Appeal Decision

Appeal Ref: APP/R5510/D/22/3292396

9 Garth Close, RUISLIP, HA4 9PT

- The appeal is made under section 78 of the Town and Country Planning Act 1990 against a refusal to grant planning permission.
 - The appeal is made by Mrs and Mrs Gez Masnavi against the decision of London Borough of Hillingdon.
 - The application Ref 76840/APP/2021/4011, dated 28 October 2021, was refused by notice dated 25 January 2022.
 - The development proposed is a two storey side & rear extension.
-

Proposed Two Storey Side and
Rear Extension.

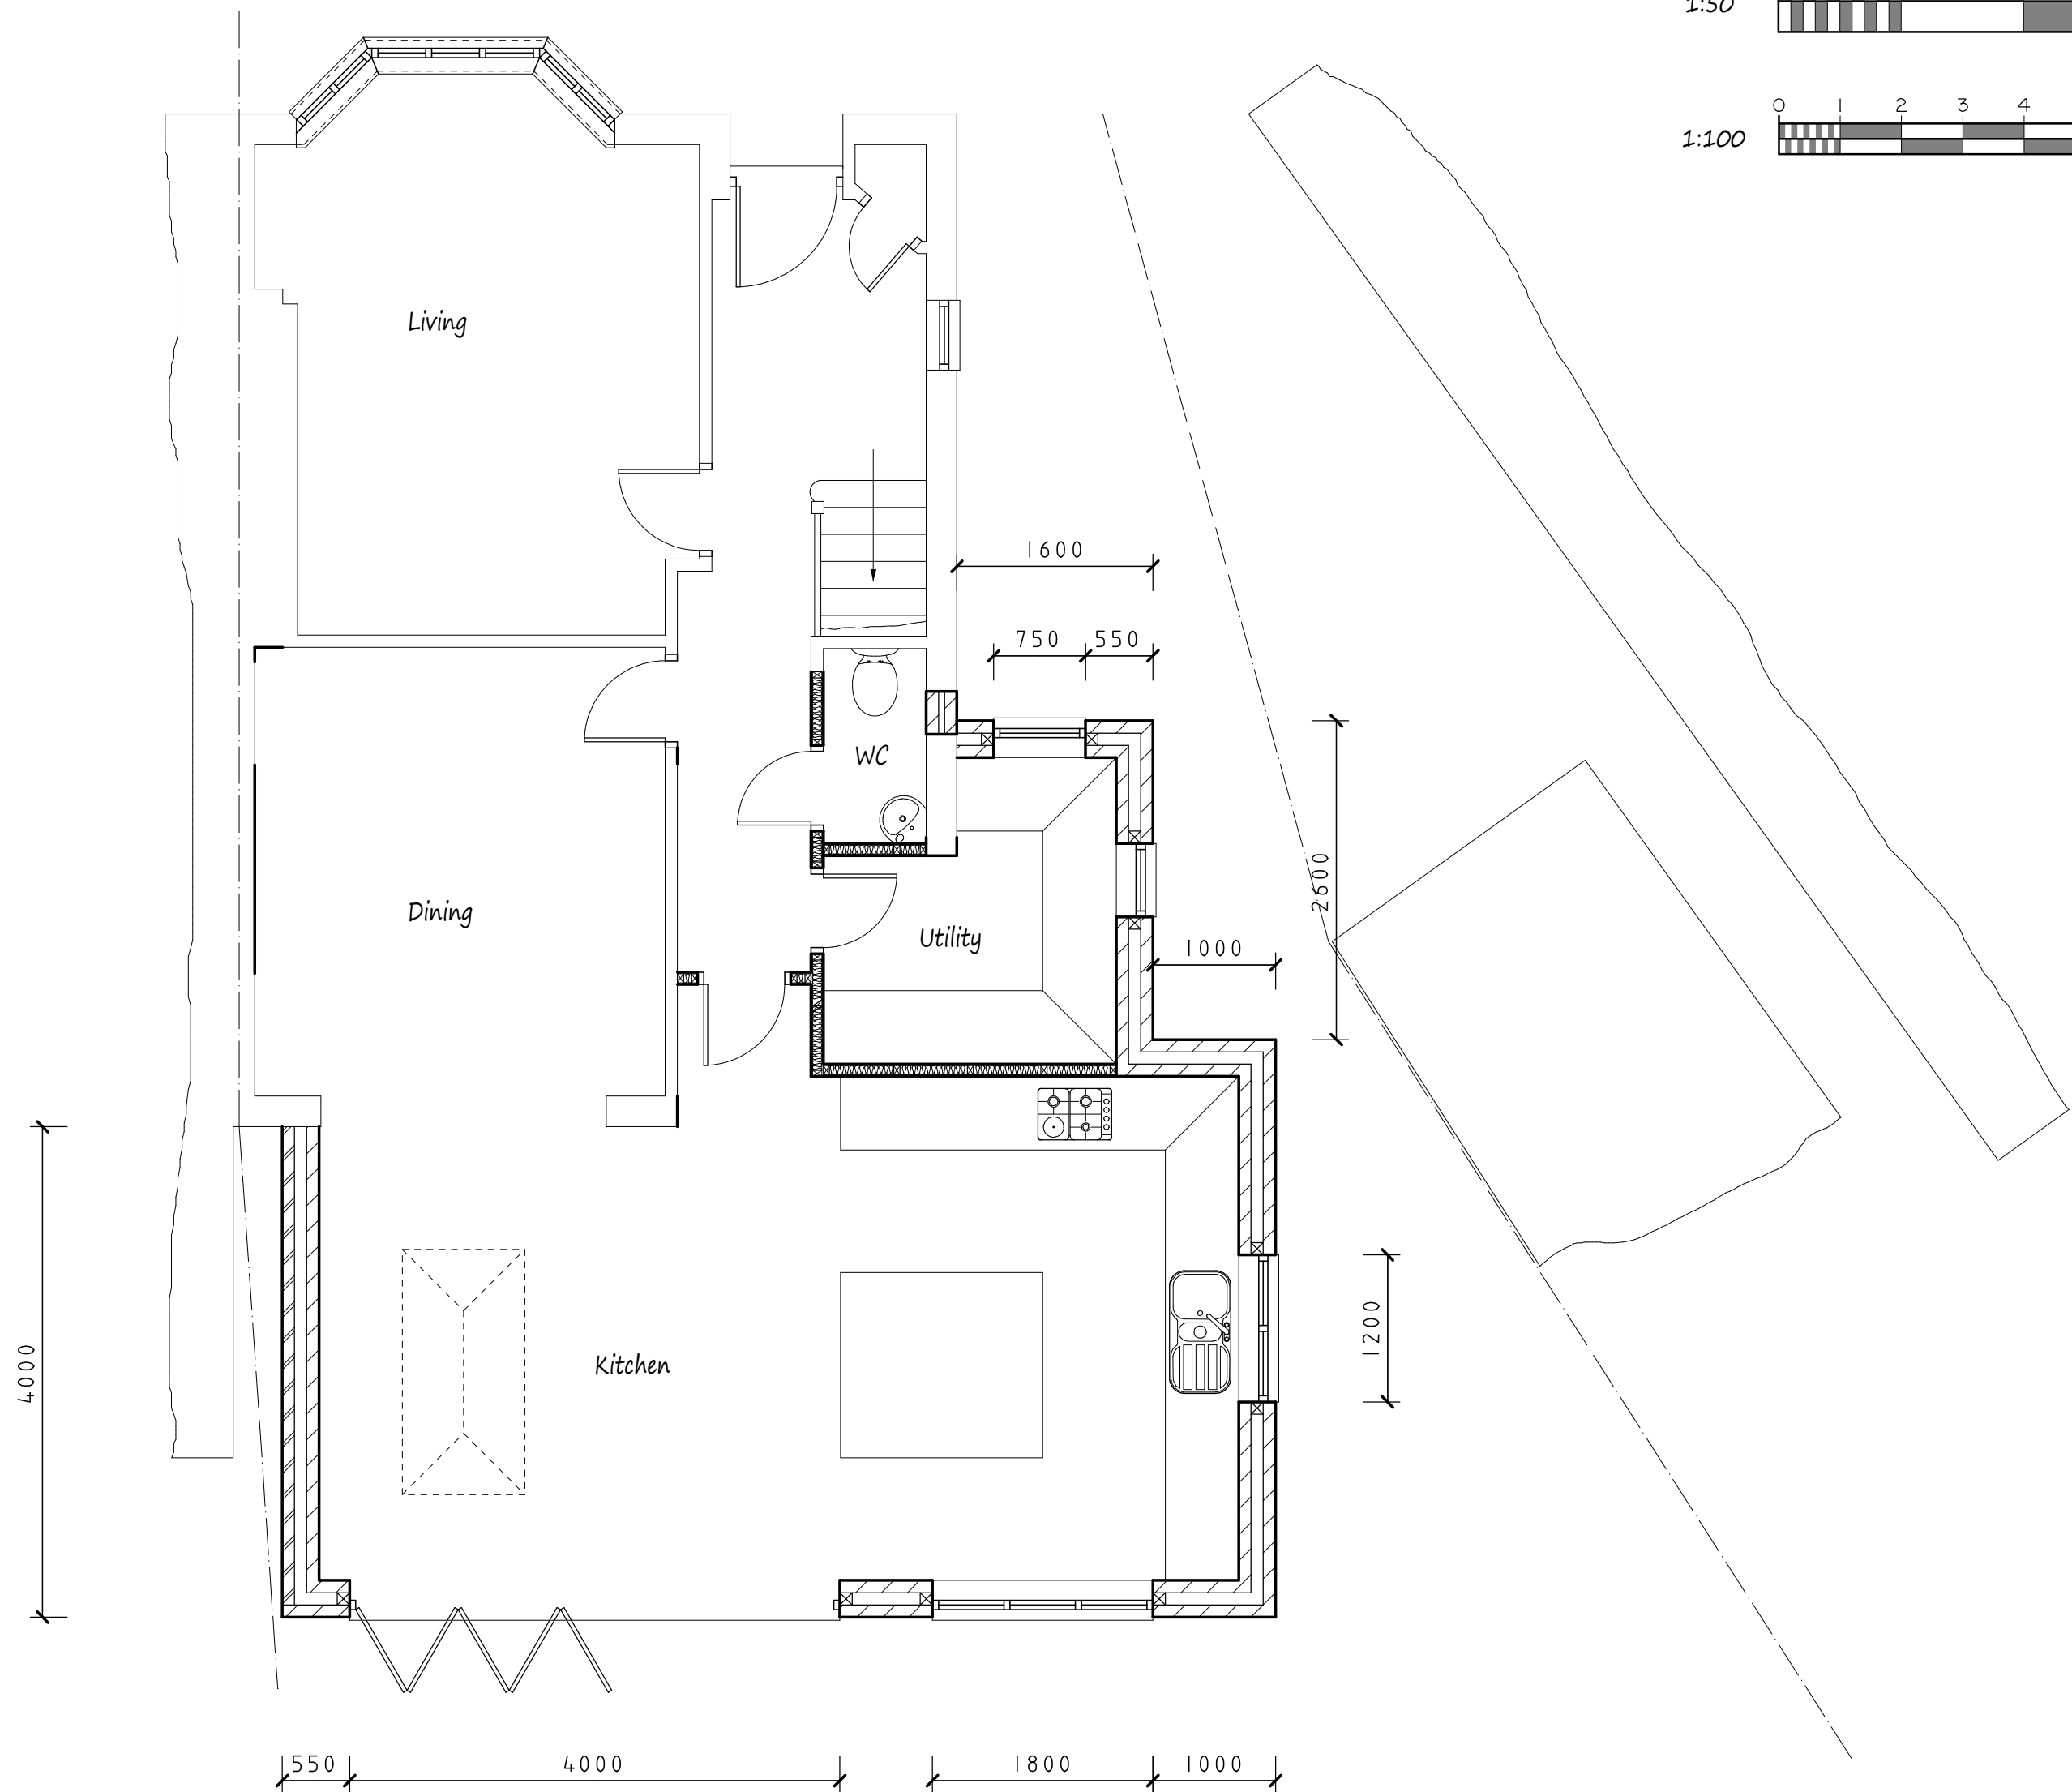
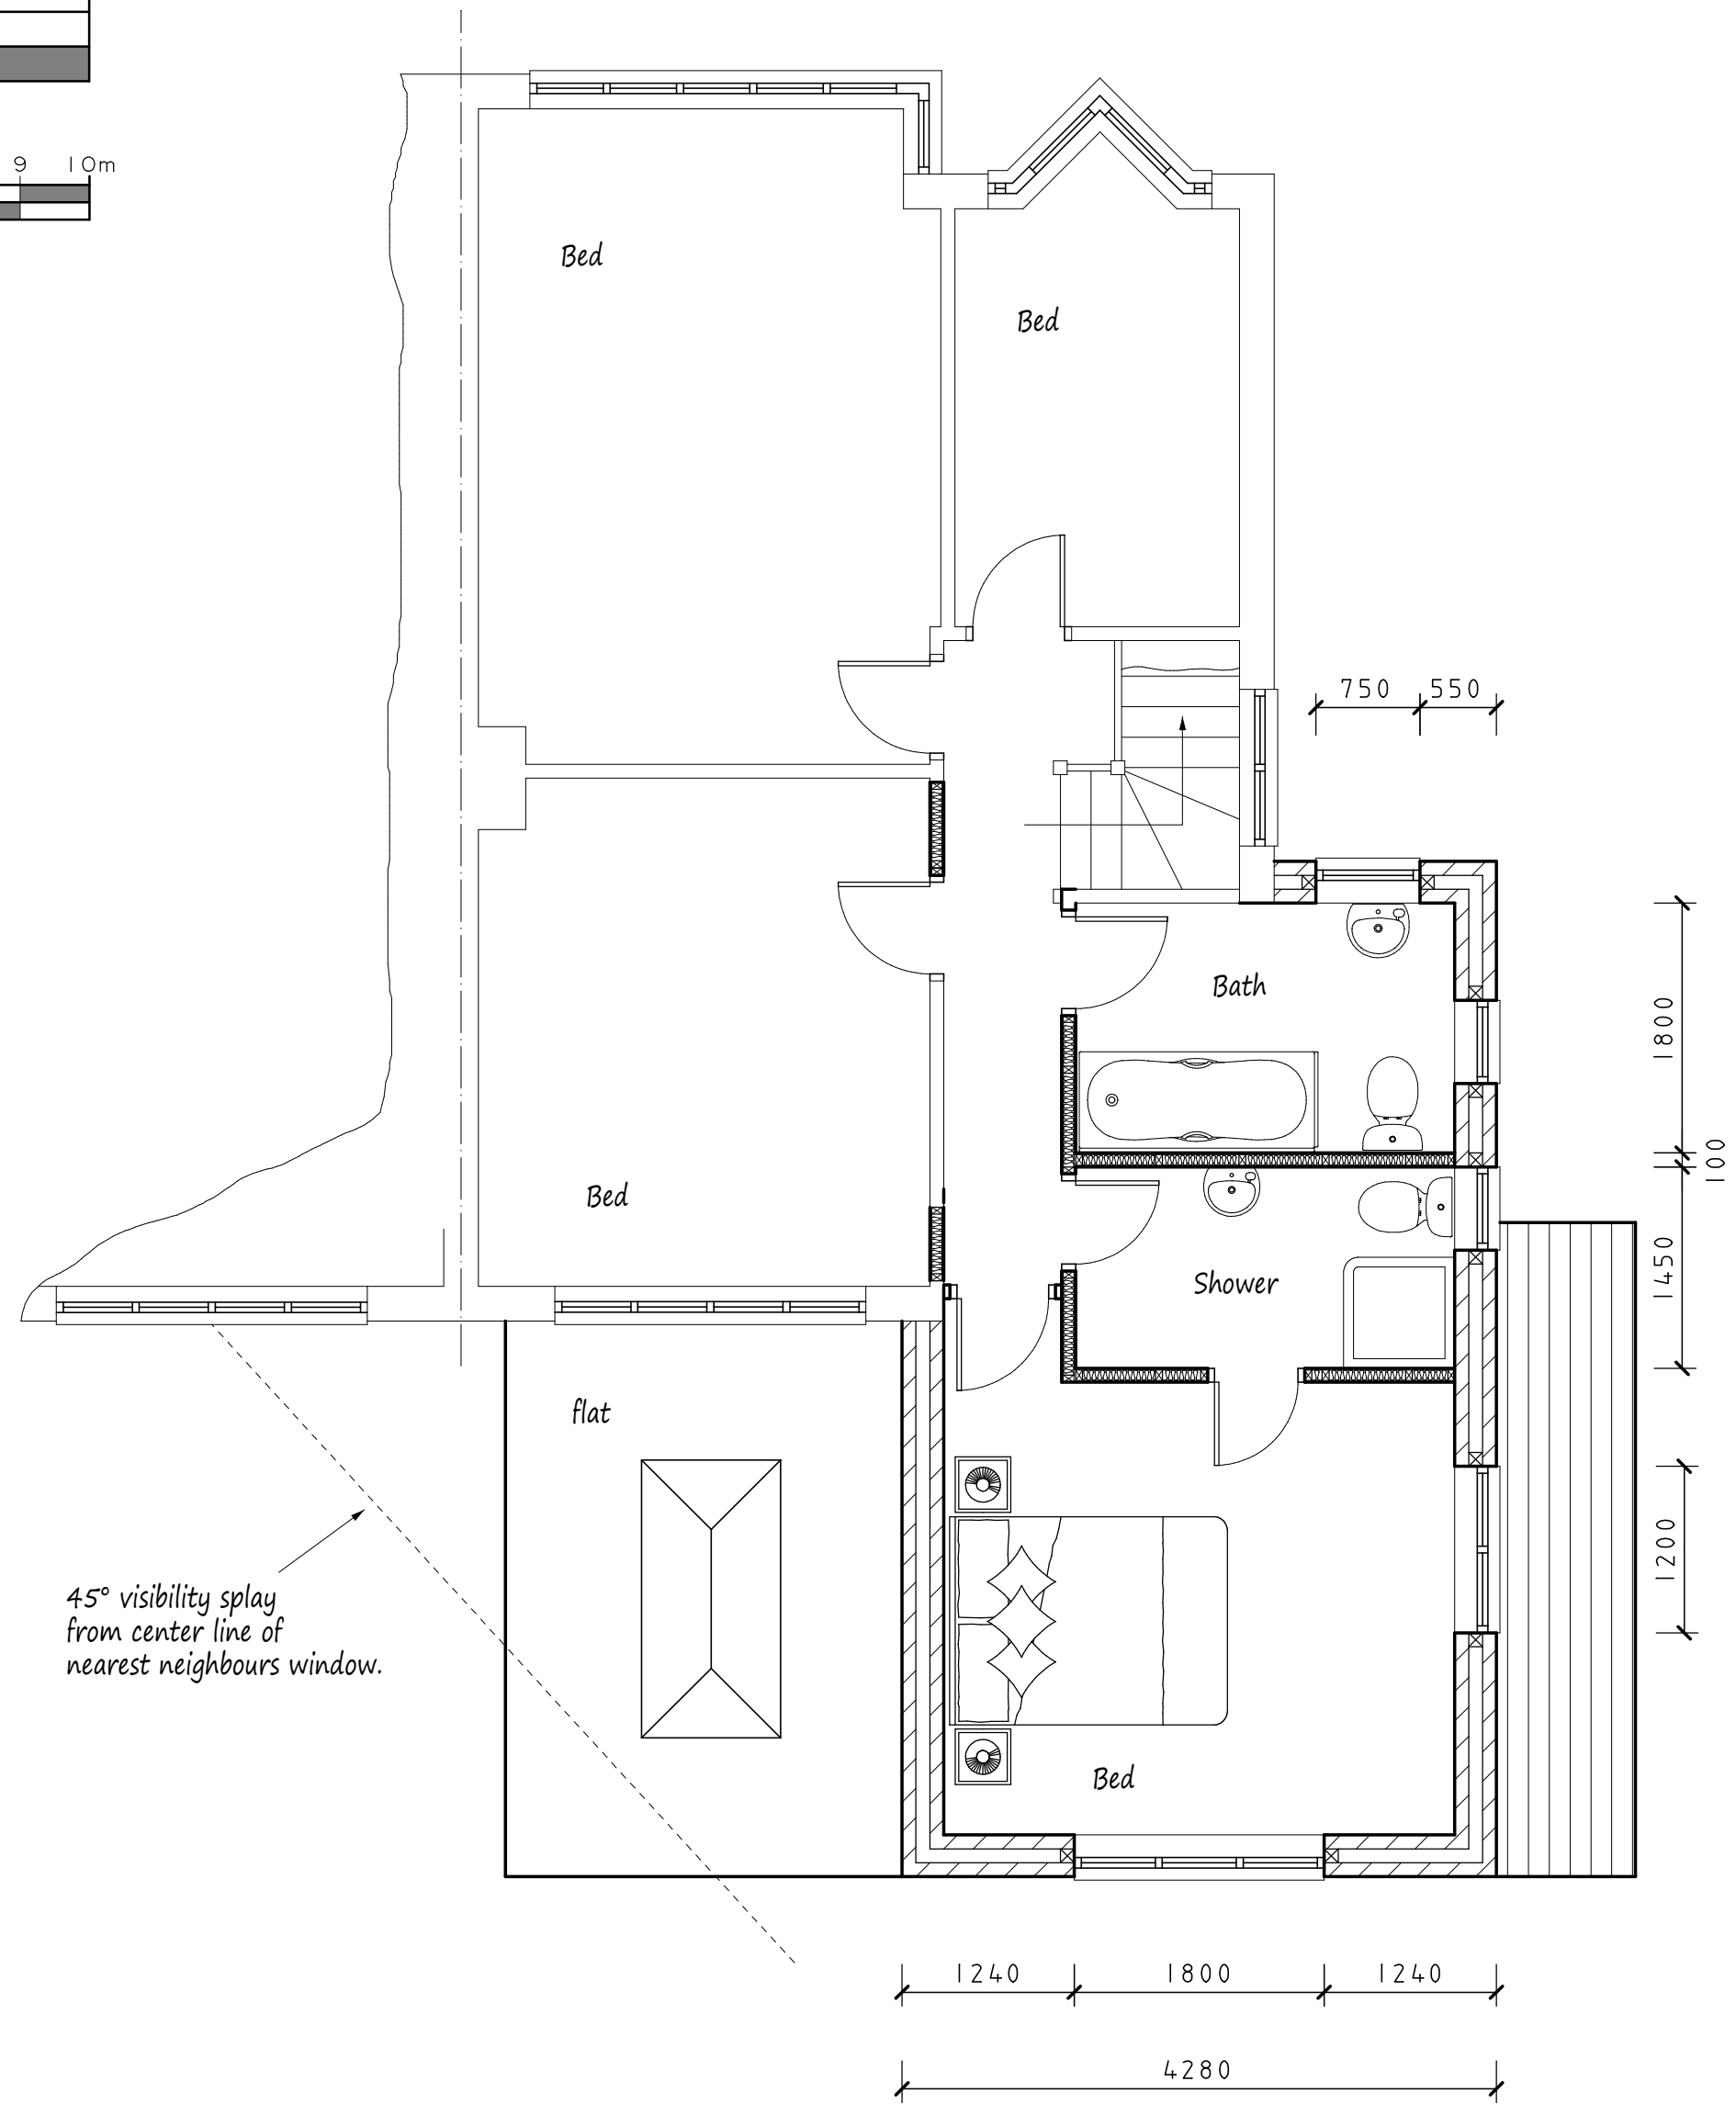
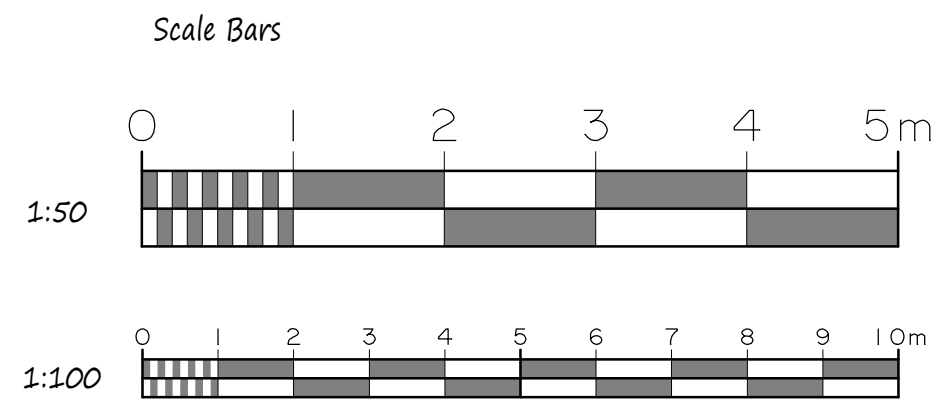
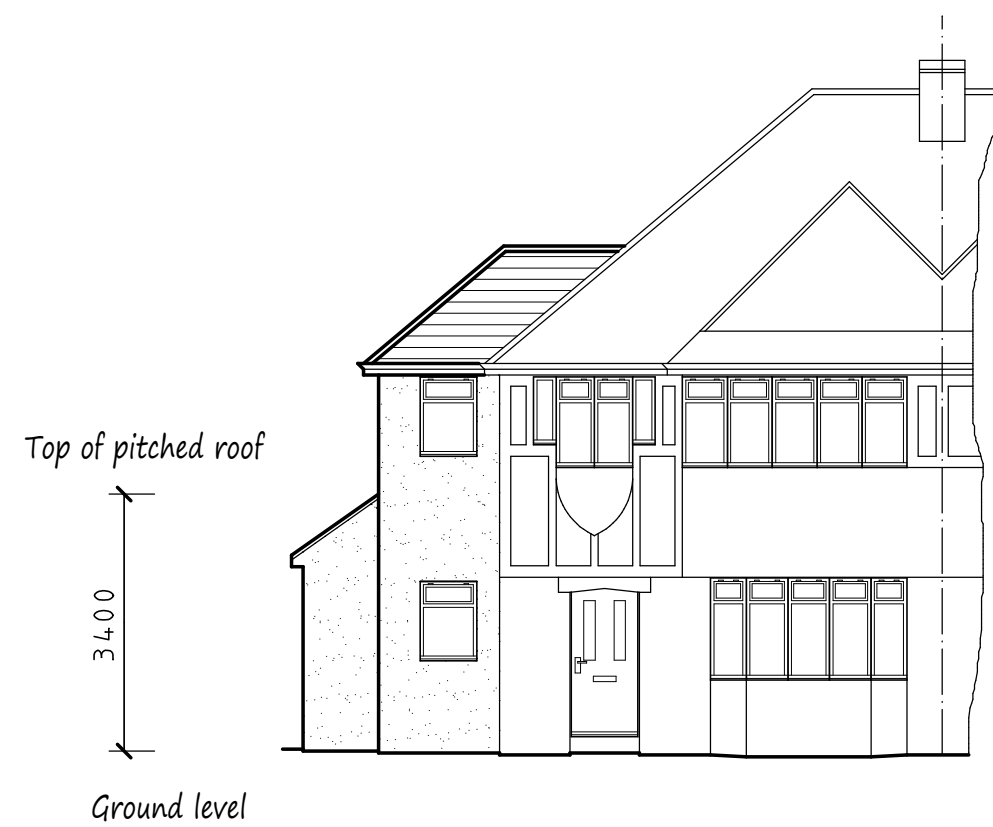
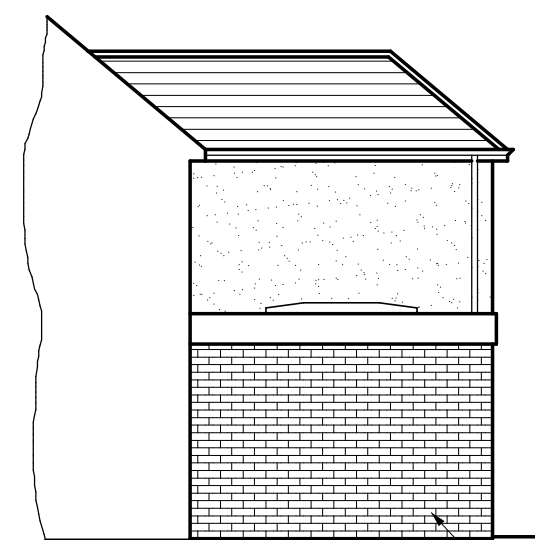
5. The Council have raised concerns regarding the proposed roof-form. The plans indicate a flat-topped roof with sloping sides, referred to as a "crown roof". Whilst this is not a conventional treatment for buildings of this type, the flat top would not be evident in views into the site, with the sloping sides appearing as a conventional pitched roof. I therefore do not consider it to be incongruous in this context.

7. The properties at Nos 8 and 9 Garth Close both sit at an angle to the road with the front elevations forming the closest point between them. The side elevation of this property has a number of side windows and although most of these serve secondary rooms, one is the single window serving a bedroom. The proposed extension would sit around 4 metres from No 8 at its closest point and the 2 storey element would sit at around 7m from the bedroom window.

8. I have considered whether the close proximity of the extension would lead to harm to the living conditions of adjoining occupiers. The dwellings already sit relatively close and the proposed extension would reduce this further, by over 2 metres at the closest point. However, the angled juxtaposition of the buildings would allow penetration of light from the north. As such, I am satisfied that this would not cause a significant loss of light to the landing or bathroom windows, which are secondary rooms. Furthermore, in relation to the bedroom due to its location on the upper floor it would also be unlikely to suffer a significant reduction in available light.

9. In relation to outlook, whilst the room would lose much of its available view of the neighbouring garden and the outlook from the room would be diminished, due to the angled juxtaposition of the buildings, the room would retain some open aspect to the north. The reduction in outlook would therefore not occur to such a degree that it would be significantly overbearing, or such that it would significantly harm the living conditions of those using the room.
